PLAN REVIEW SHEET

Petition #: RZP 2023-015

Address: 2501 Wilkinson Blvd.

Request: TOD-CC

RZ - 200

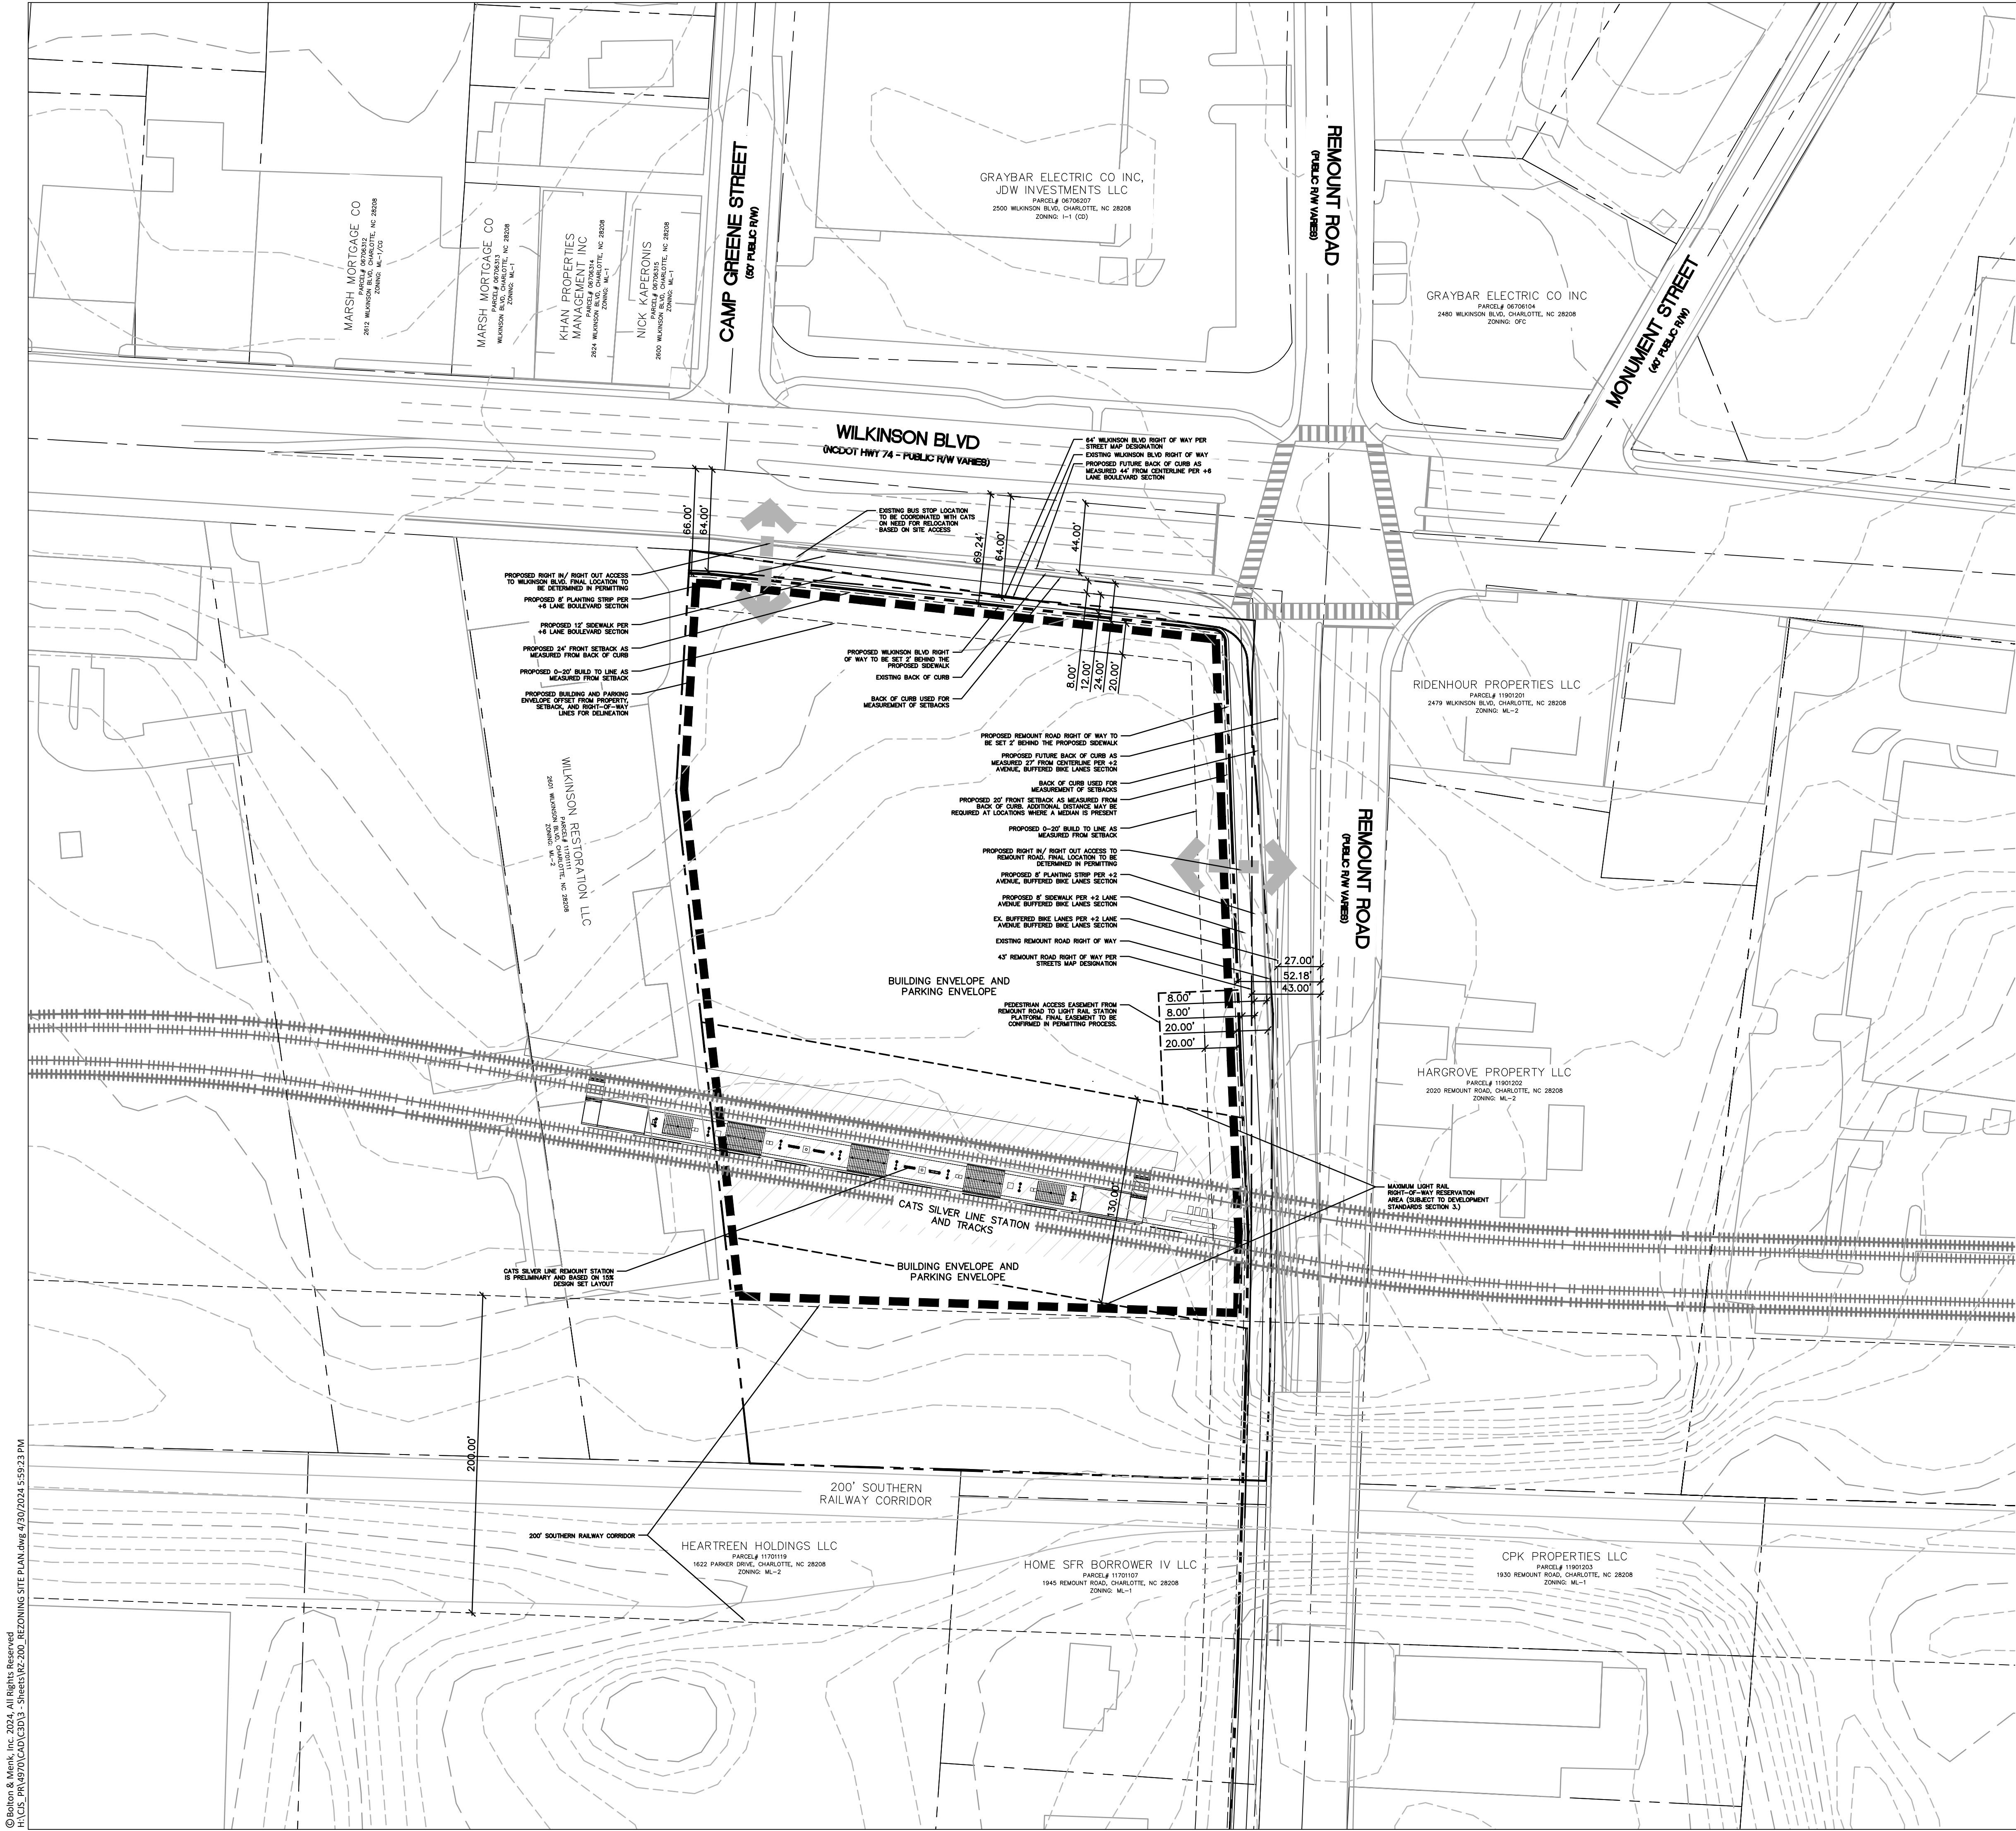
The site is located at the proposed LYNX Silver Line light rail transit corridor and Remount Road station. The minimum required right of way for the light rail corridor is 70 feet (35 feet measured from the centerline of the tracks). However, additional area will be needed for the corridor and the station platform. CATS is requesting a conditional rezoning petition to include the reservation of the light rail corridor and station area as shown on image 1.
